REFUSAL REVIEW

Land adjacent 70 Bedford Road, Holland on Sea

SITE:	70 Bedford Road - Holland on Sea
PROJECT No:	21.538
DOCUMENT No:	PAR-01
APPLICATION:	20/00370/FUL
DATE OF ISSUE:	03/03/21

PROPOSED FRONT ELEVATION 1:100 @A1
 PROPOSED SIDE ELEVATION 1:100 @A1
 PROPOSED REAR ELEVATION 1:100 @A1
 PROPOSED SIDE ELEVATION FACING GARDEN 1:100 @A1

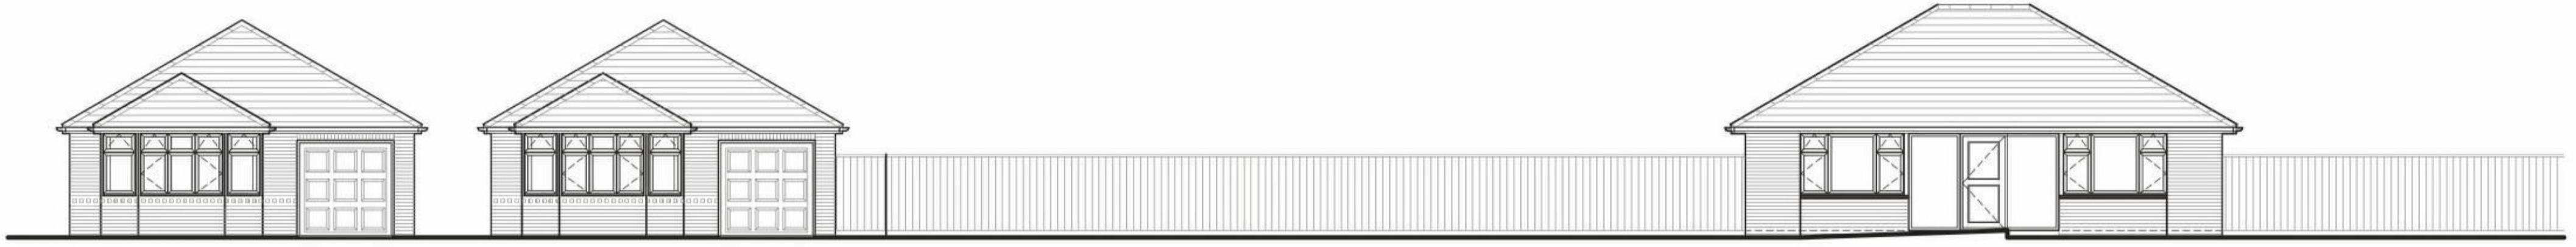
The design of the proposed one bedroom dwelling is considered basic and makes a neutral contribution to the character of the immediate area where a majority of the surrounding bungalows have gable or bay window features facing the road. The front elevation of the proposed bungalow projects a distance of 1.1 metres further forward than the donor dwelling and a distance of 2.9 metres further forward than the dwelling at 72 Bedford Road giving rise to its prominence in the

The design of the proposed one bedroom dwelling is considered basic and makes a neutral contribution to the character of the immediate area where a majority of the surrounding bungalows have gable or bay window features facing the road. The front elevation of the proposed bungalow projects a distance of 1.1 metres further forward than the donor dwelling and a distance of 2.9 metres further forward than the dwelling at 72 Bedford Road giving rise to its prominence in the street scene which is out of character along this southern side of Bedford Road.

The proposal seeks to improved articulation. It is agreed that the previous applicant had put forward a bland proposal that had not reference to the existing street-scene. The comment draws attention to gable frontages but it should be noted that in close proximity to the site on the side of the application site a number of hips are present. The images below indicate the 2 adjacent dwelling that benefit from projecting hips rather than gable. It is because of this local context that a hip approach is taken to the design.

It is agreed that the previous application provided a poorly positioned dwelling lacking reference to the adjacent dwellings and sat forward of all dwellings within Bedford Road. The dwelling now looks to take reference from both dwelling and create a transitional dwelling, introducing the projecting hip/bay to line with the dwelling of 70 Bedford Road and the main bulk of the dwelling lining with 72 Bedford Road.

PROPOSED STREET-SCENE ELEVATION 1:100 @A1

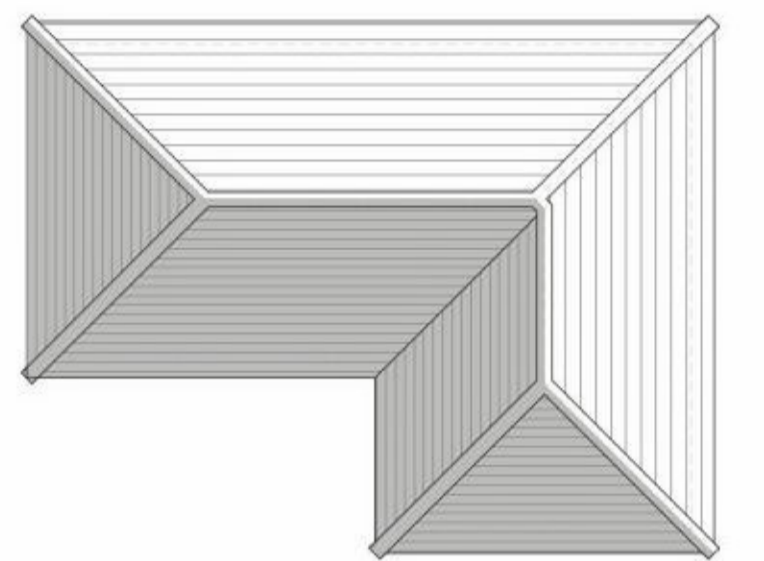
For the reasons set out above, the cramped appearance, overdevelopment of the application site leading to undersized private amenity space will result in an unacceptable and unduly prominent form of development to the serious detriment of visual amenity and the character of the area. The proposal is therefore contrary to the aims and aspirations of the afore-mentioned policies and guidance.

The new spacing now provides a design that respects the existing rhythm of the street-scene and increases separation between the proposed new dwelling and 70 Bedford Road.
